STIP A-0009CA

Concurrence Point 4B Hydraulic Design Review Meeting Minutes

Subject: STIP No. A-0009CA, Graham County
Concurrence Point 4B Virtual Meeting

Purpose: The purpose of the meeting was to review and discuss the 30% drainage plans for STIP A-0009CA. The project goes from Robbinsville to Stecoah.

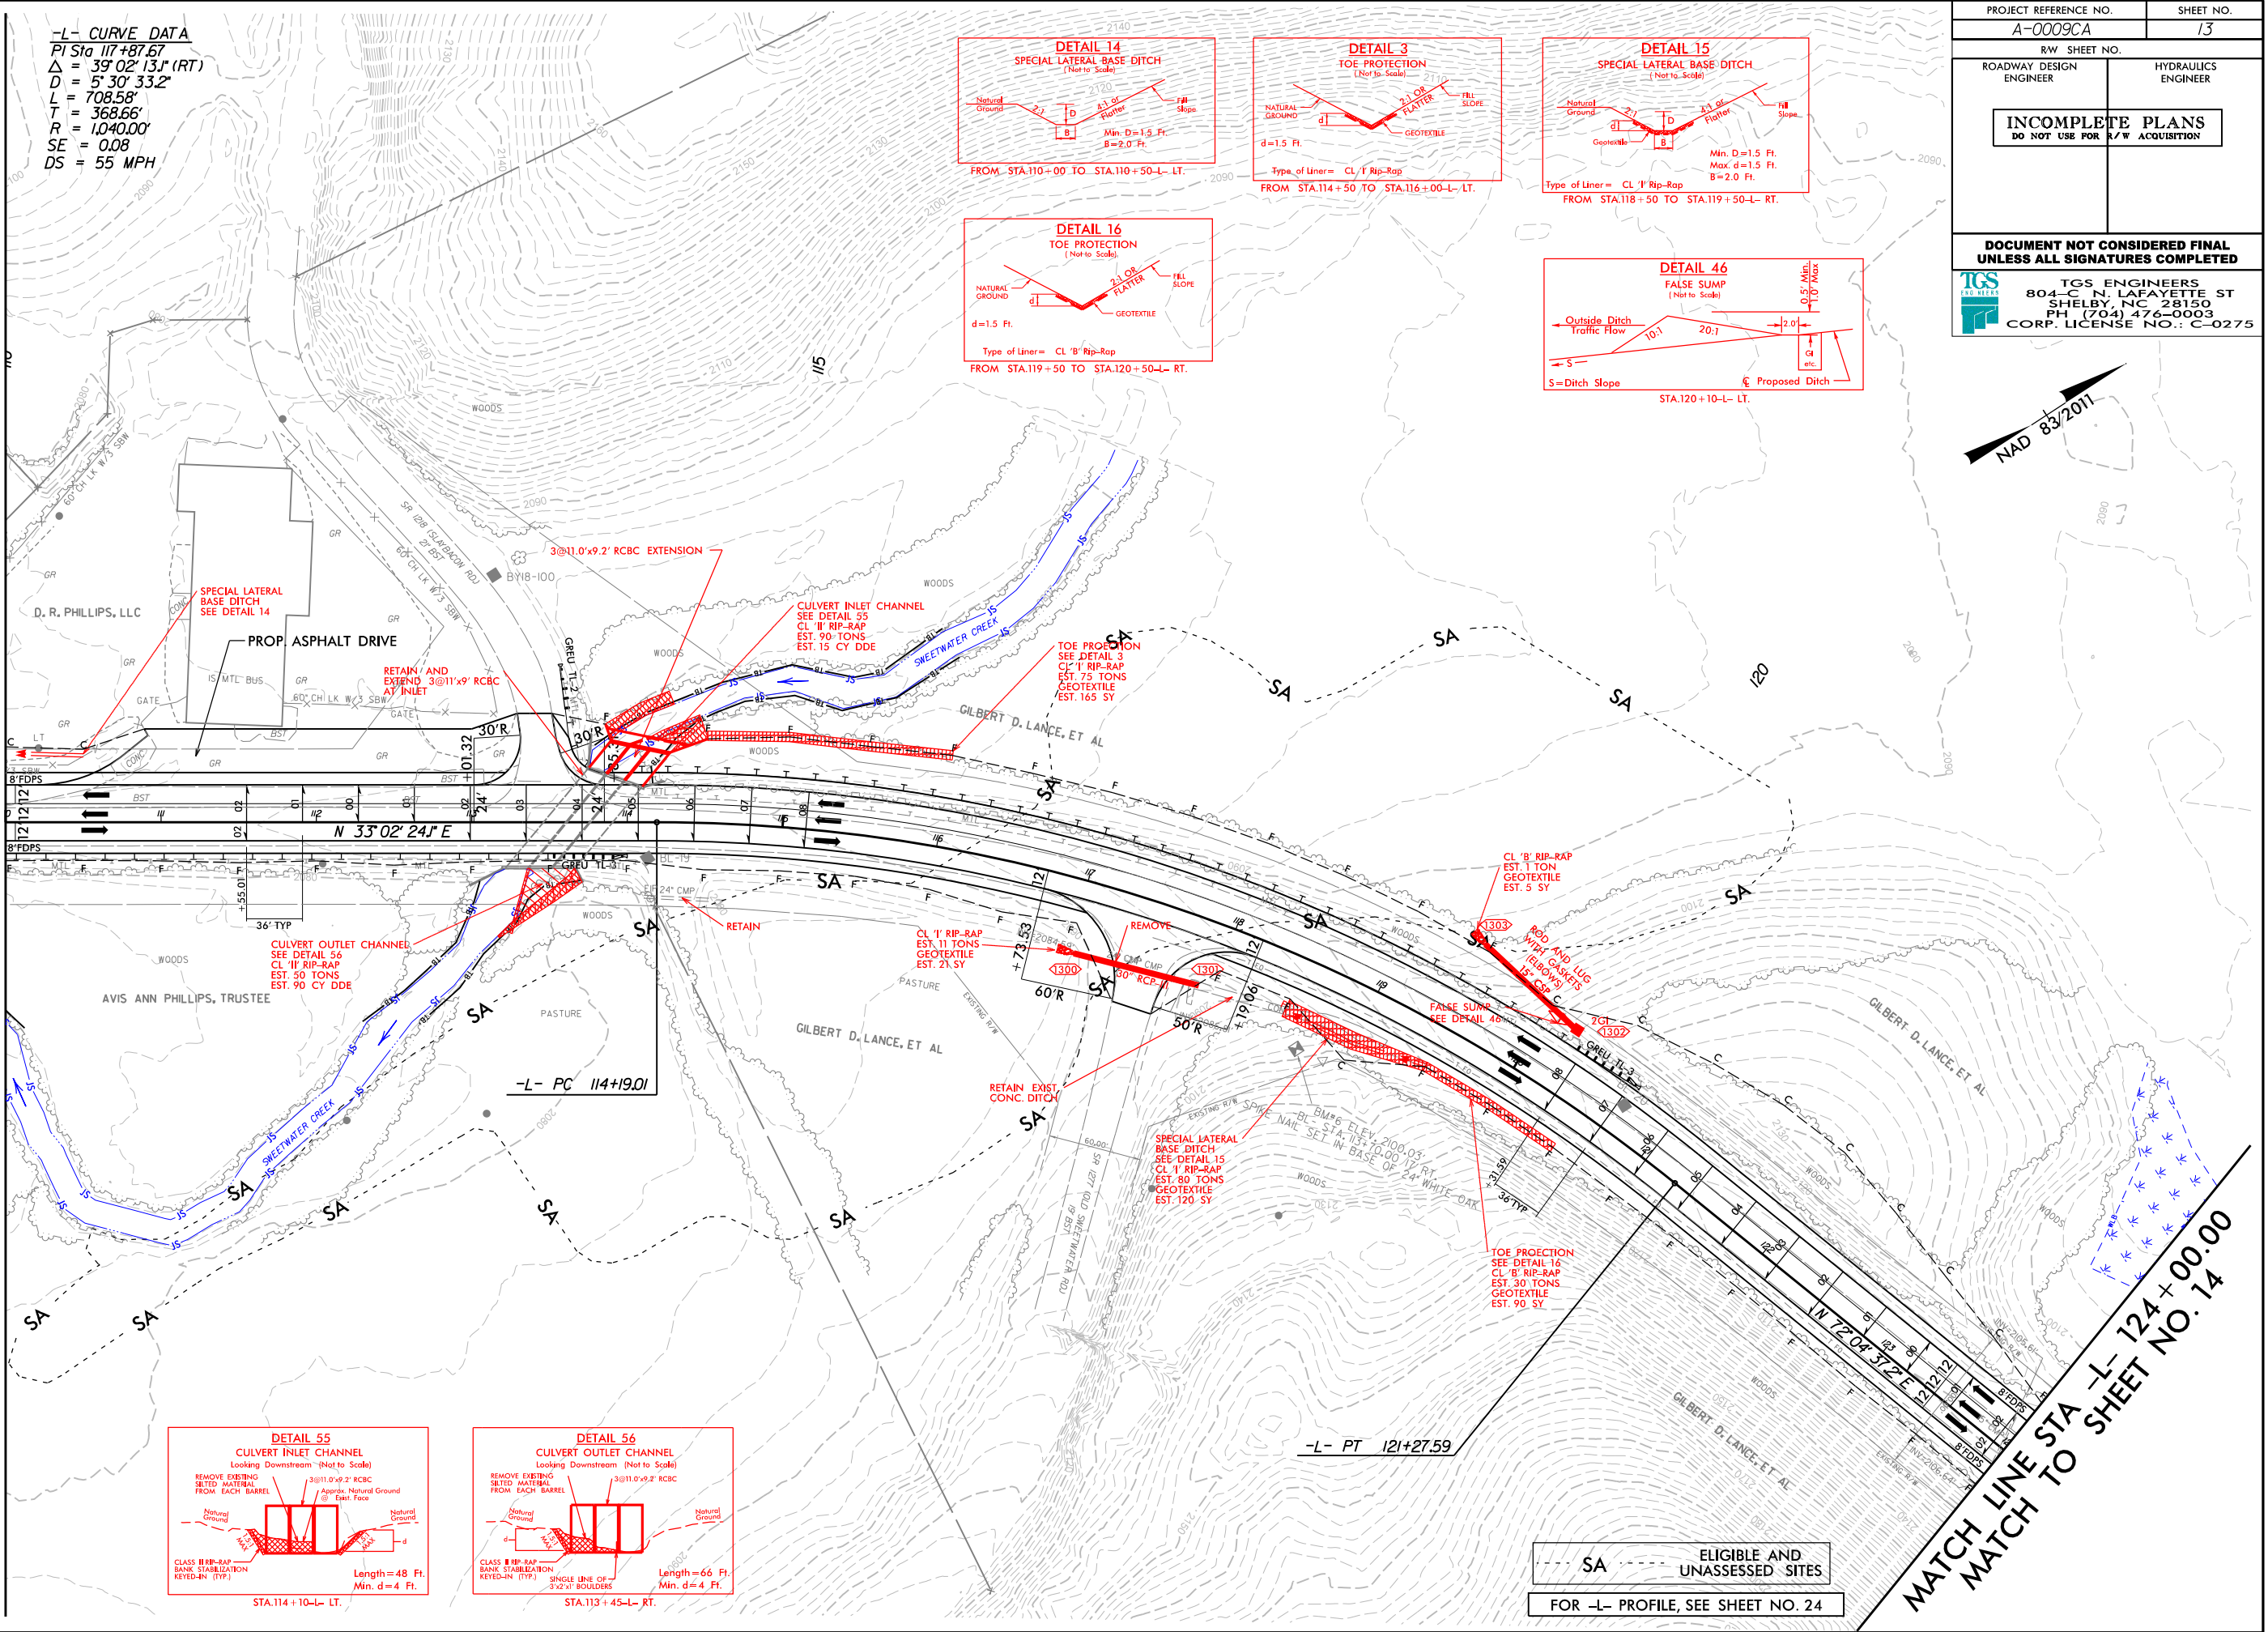
Impacted jurisdictional features on this sheet include the crossing of Sweetwater Creek (WS-III, Tr) at L 113+70. The existing 3 @ 11'x9' RCBC will be retained and extended upstream. Low flow will be maintained in west barrel to match existing conditions. A 1.5' weir wall upstream will maintain normal depth of flow. The accumulated silt will be cleaned out of the middle and eastern barrels. A boulder wall is proposed at the outlet to maintain low flow.

- Crystal asked why a wall is being used on inlet side. Jay and Randy answered that the barrels need to be open for high flow. The floor slab will be extended about 7' upstream and the wall will be placed on floor slab to match existing conditions. The channel bank will tie into wall with rip rap behind.
- Kevin asked if CSRs are included in drainage plans. Jay mentioned that CSRs are not typically included but permit drawings will have profile views and detailed cross sections for culverts.
